Fire Marshal Division

Re: Natural Stone Design
148 Jarco Dr.
Fuquay-Varina, NC 27526

Application Number : BCOM2104-0004

PROPOSED SITE PLAN

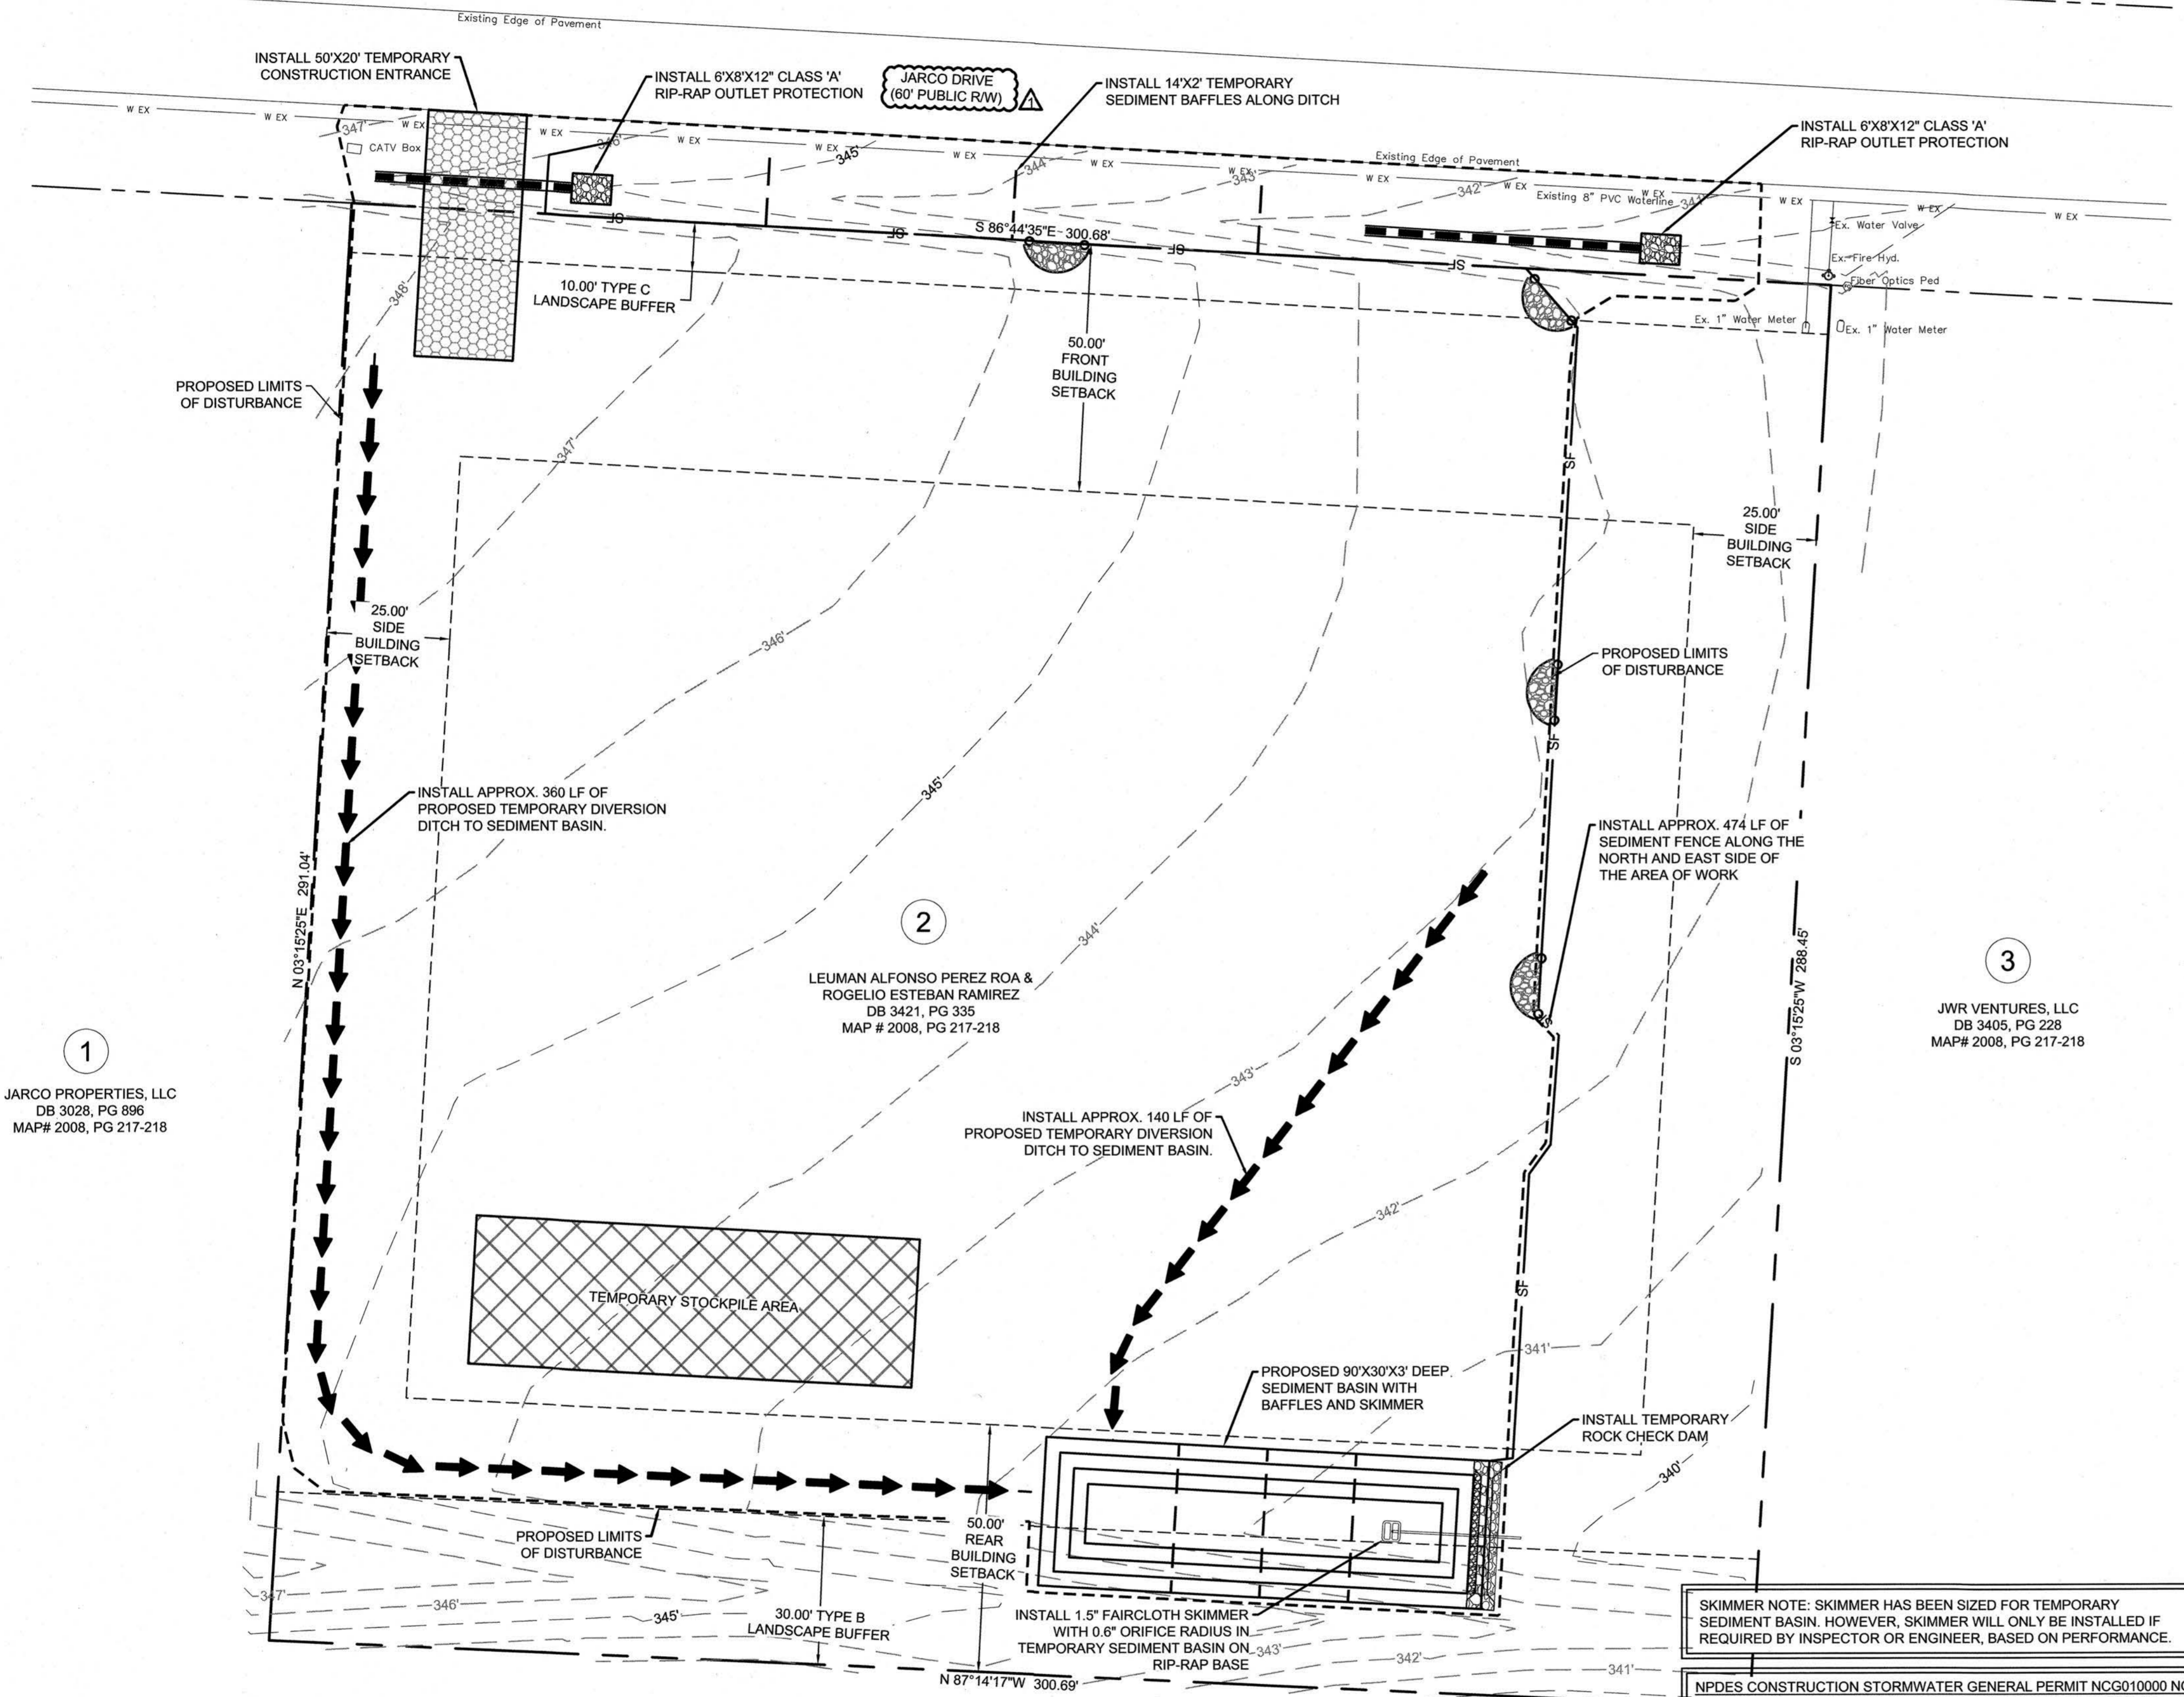
- **Automatic fire-extinguishing systems.**
 - Show Fire Department Connection on the on the site plan within 50ft. of the existing hydrant.
- **Fire alarm construction permits.**
 - A construction permit is required for the fire alarm installation. Submit complete shop drawings consistent with the architectural design documents, specifications and NFPA 72 for a separate review. Shop drawings shall include detail as described in Section 907.1.2 of the NC State Fire Code. Contractor must obtain the construction permit for the fire alarm system before commencement of any work.
- **Fire Flow (NFF)**
 - Private fire service water mains shall be installed according to NFPA 24. All fire protection water mains shall be inspected by a fire official before covering. A contractor's underground flush and test certificate is required at time of fire official inspection.
- **Statement of Compliance**
